Urban Design Review Panel Report

6310 Hazeldean Road

August 25, 2025

Response to UDRP Recommendations

1 NORTH ELEVATION - HAZELDEAN ROAD
ÉCHELLE: 1 : 250

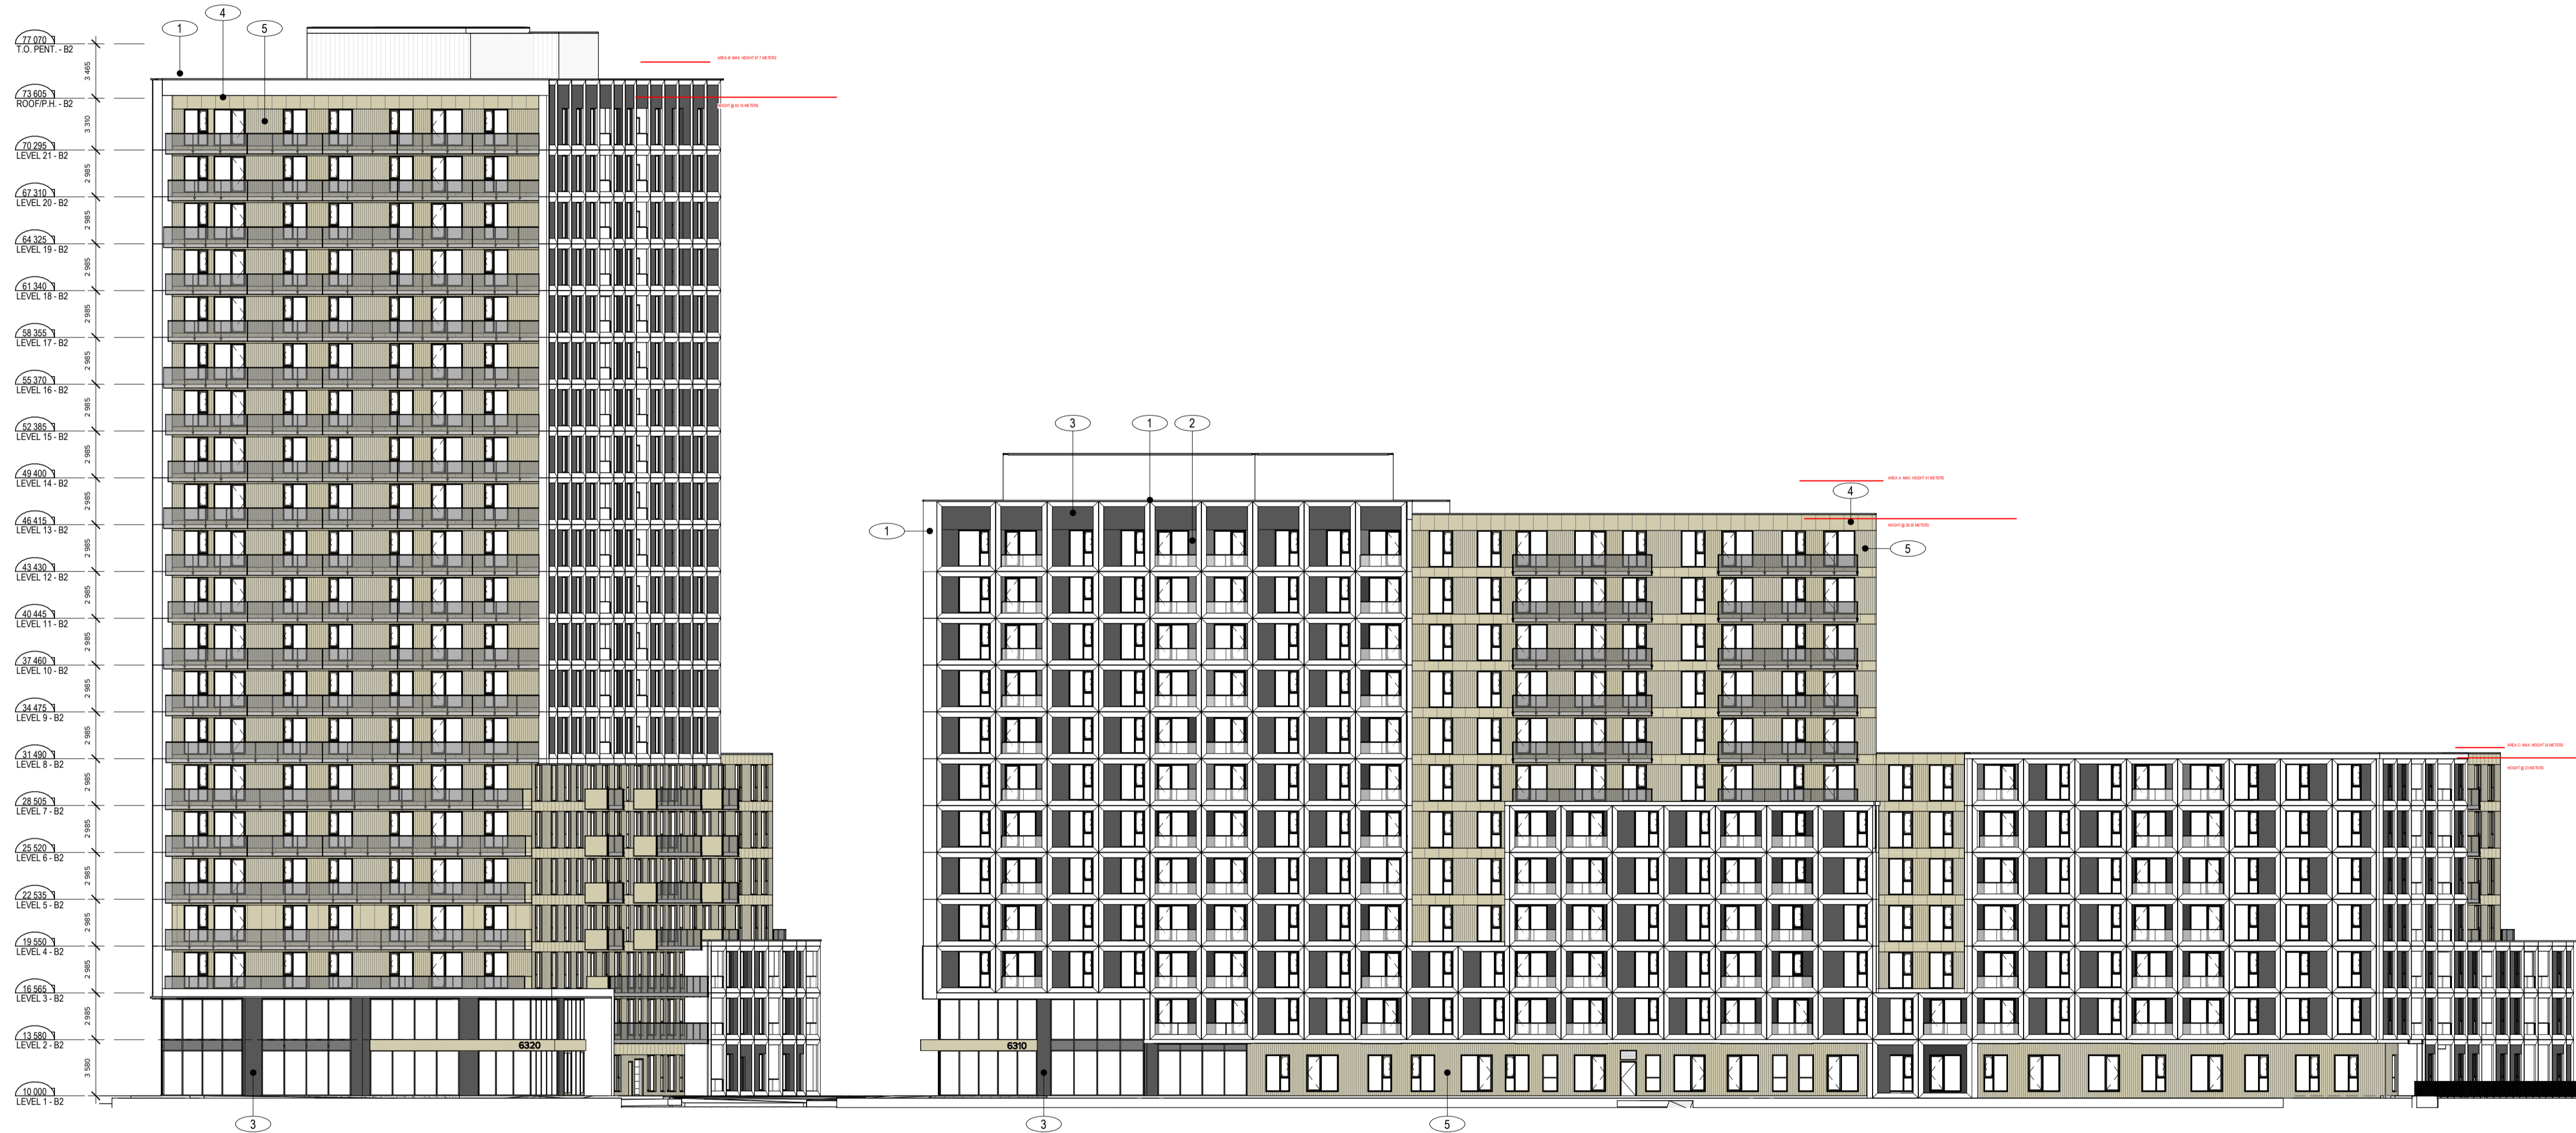
1.2	The Panel raised concern about the development reading as a superblock. The Panel recommends further articulation or variation in massing, particularly in the middle building, to help visually break down the composition.	The midsection of Building 1 has been slightly recalibrated to accentuate the effect of fragmentation while preserving the intended monolithic character. The central white mass has been raised to six stories instead of five, thereby enhancing the presence of the two fissures on either side and, consequently, reinforcing the strategy of breaking down the structure's length along Hzaldean. In addition, we propose replacing the metallic cladding initially shown in black with a "gold-champagne" finish. This warmer tone, more capable of capturing daylight, will contribute, in our view, to reinforcing the perception of multiple, smaller volumes rather than that of a single monolithic block.

1.3	The Panel supports the strong architectural expression of the tower and recommends it be treated as a distinct architectural element. The Panel suggests the tower be designed as a building "in the round," recognizing its visibility from all sides and ensuring consistent architectural treatment across all elevations.	Our design strategy prioritizes urban-oriented massing - activating the street through a thoughtful framing approach that anchors the building within its context. This deliberate volumetric composition, responsive to surrounding scale, proportion, and site conditions, reinforces both visual continuity and placemaking. Altering Building 2 into an "in-the-round" form would compromise this carefully calibrated orientation, detaching the structure from its urban context. While such a form carries its own merits, in this case it would weaken connections to adjacent streetscapes and diminish the alignment of the massing with the public realm. By contrast, maintaining the current design language ensures the building remains rooted in its surroundings, enhancing façade articulation and reinforcing material expression. To address the panel's comments, however, we propose replacing the originally black metallic cladding with a warmer "gold-champagne" finish. Less contrastive, this color softens the overall composition, creating a more uniform yet still rich interplay of materials that adds depth and refinement to the architectural expression.

4.21	The Panel recommends considering how the facade expression might help break the perceived length of the white grid in elevation with strategic interruptions or compositional adjustment.	See also response in points 1.2 and 4.17

<p>JOAN RENAULT LICENCE 10089</p>	DOSSIER 25-1839	REV. NO. 1
	DESSIN NO. A-301	DATE MAY 2025
	ÉCHELLE 1 : 250	DESSINÉ PAR Author
	VÉRIFIÉ PAR Checker

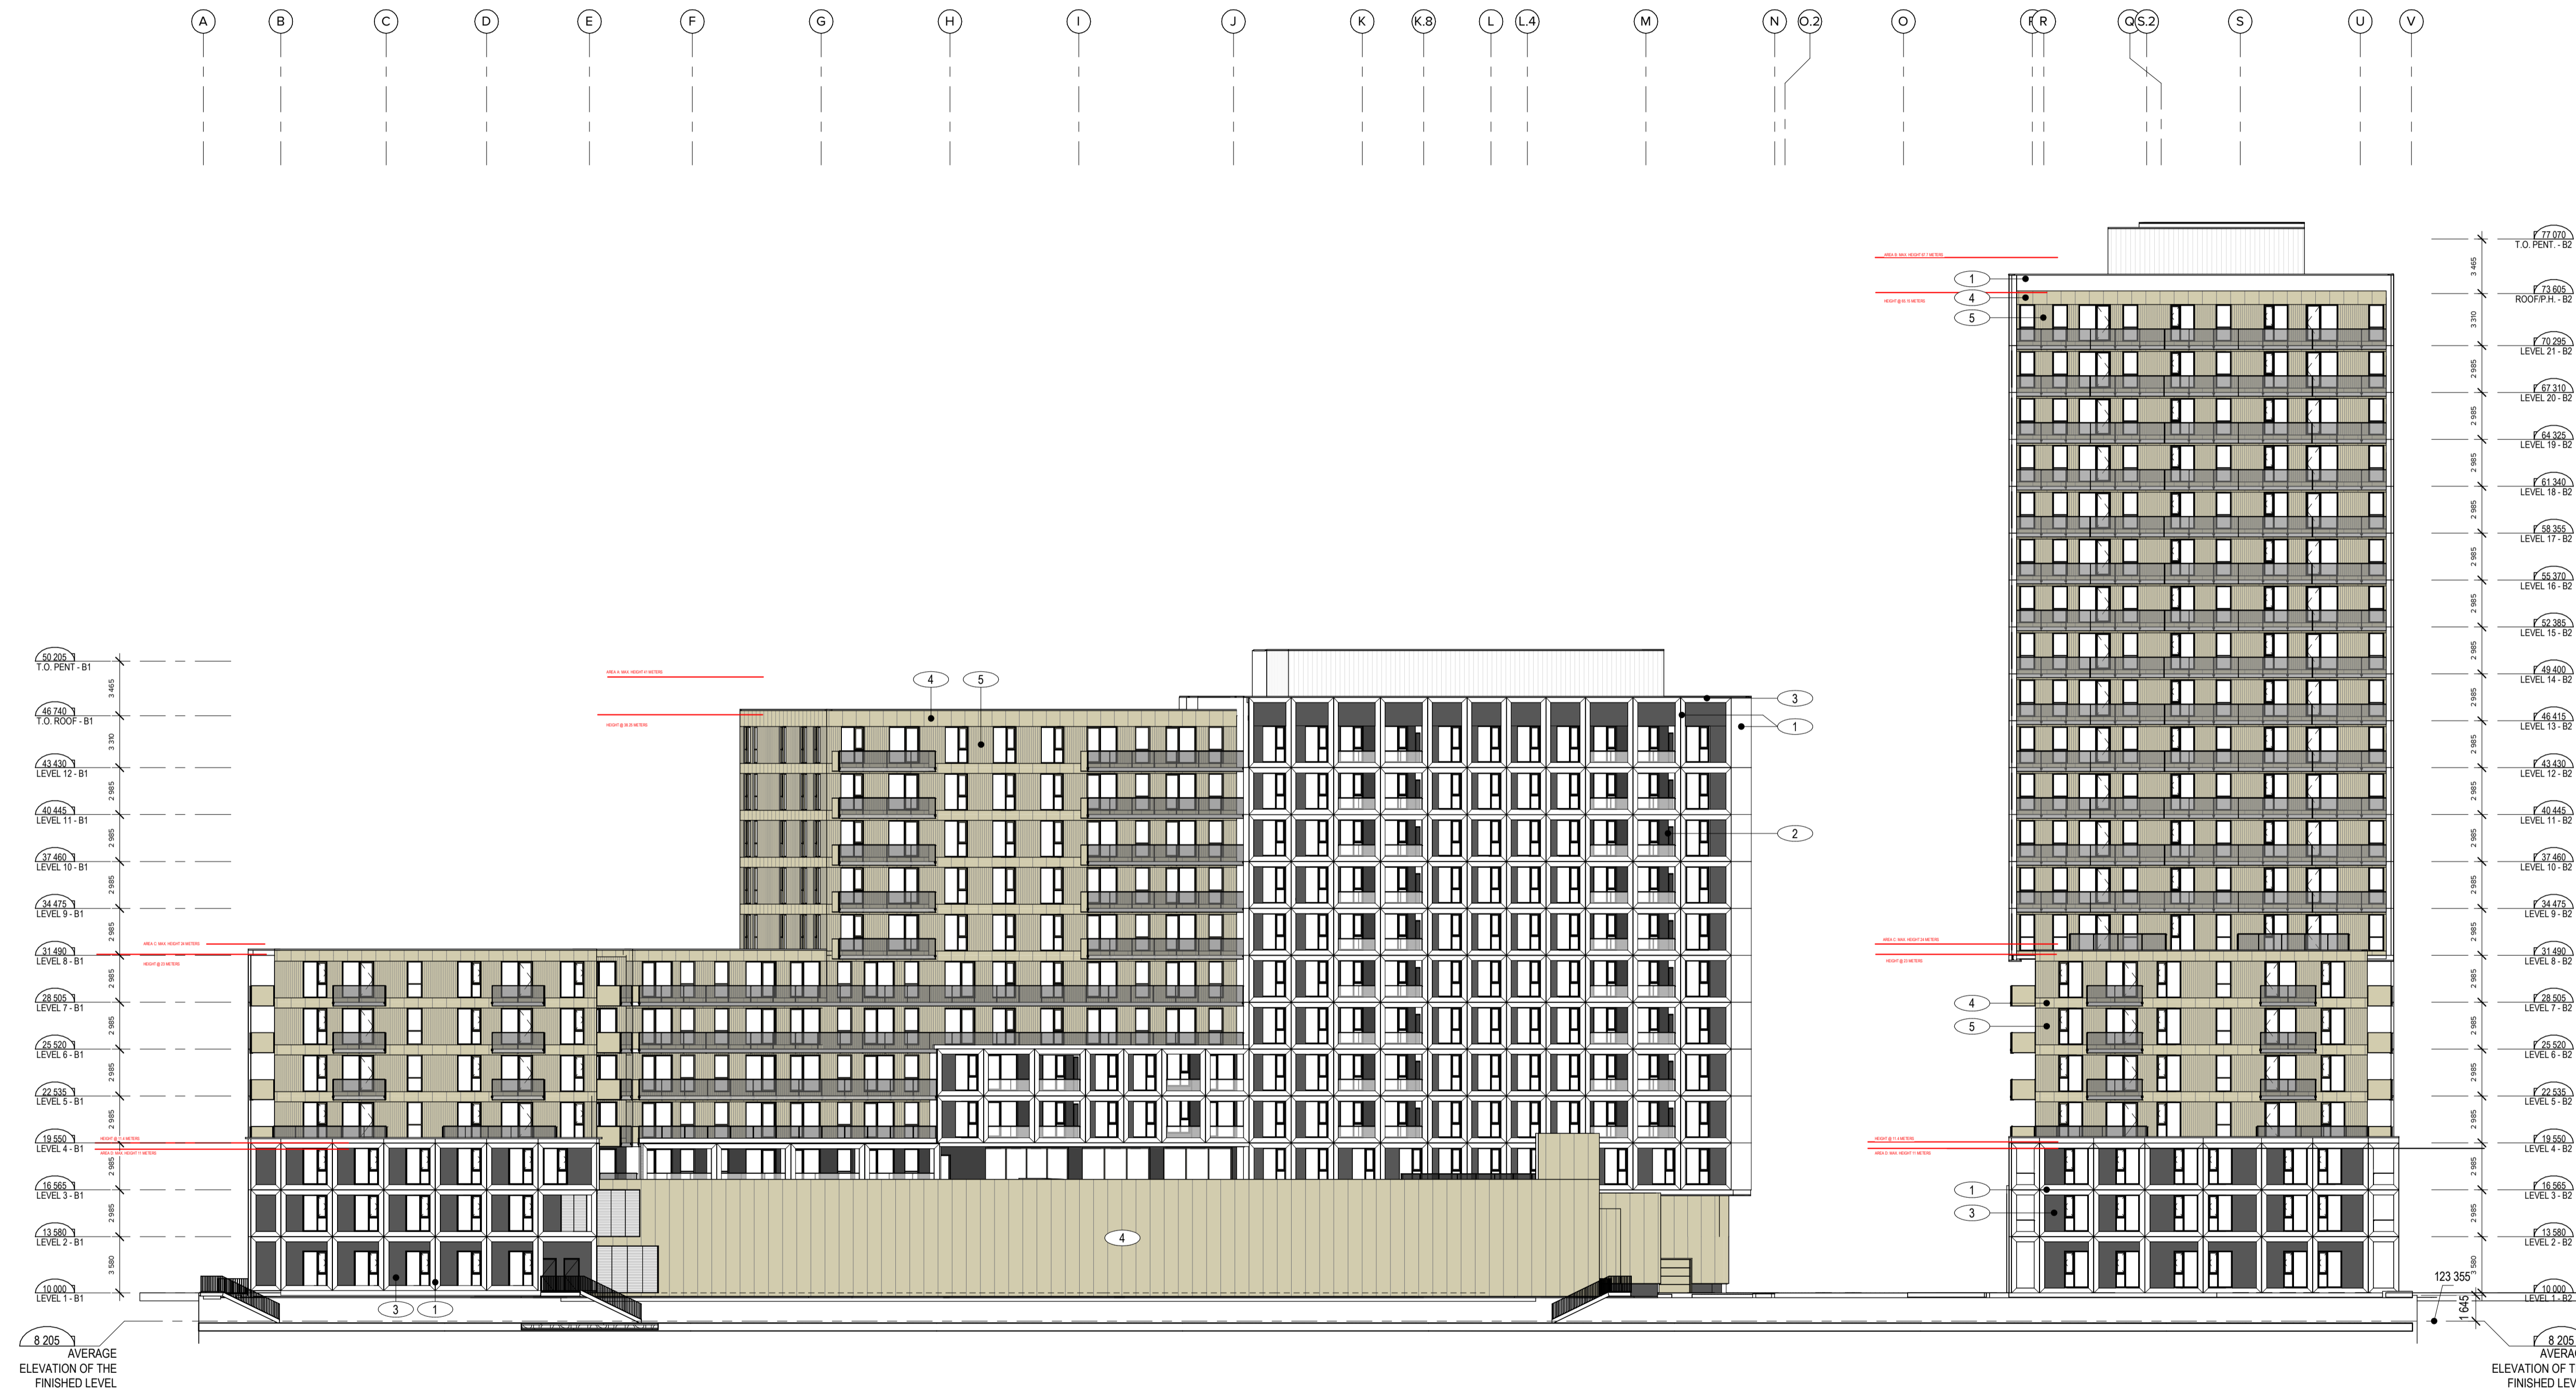
4.19	The Panel suggests refining the gold/champagne insulated panels that meet grade, which may appear vulnerable, and recommends durable detailing.	Where the gold-champagne insulated panels meet the ground floor, we have raised the base of the panels 200 mm above grade. The lower portion of the wall will be in concrete, providing a resilient finish that complements the foundation insulation strategy. This robust transition layer not only protects against physical impact and weathering but also visually reinforces the building's base, in line with the panel's emphasis on durable detailing.

4.20	The Panel suggests repeating the champagne panel treatment at the other entrance to highlight and differentiate it from the base expression.	The champagne-gold panel treatment spans the entirety of the elevations, imparting a modern and celebratory aesthetic that feels both inviting and refined. The warm metallic contrast against white evokes a sense of luxury and visual depth—drawing attention without harshness and elevating overall engagement with the façade. Meanwhile, the white and gold pairing balances warmth and brightness. The white concrete surfaces reflect light effectively, enhancing material clarity and ensuring the composition remains luminous and visually coherent.
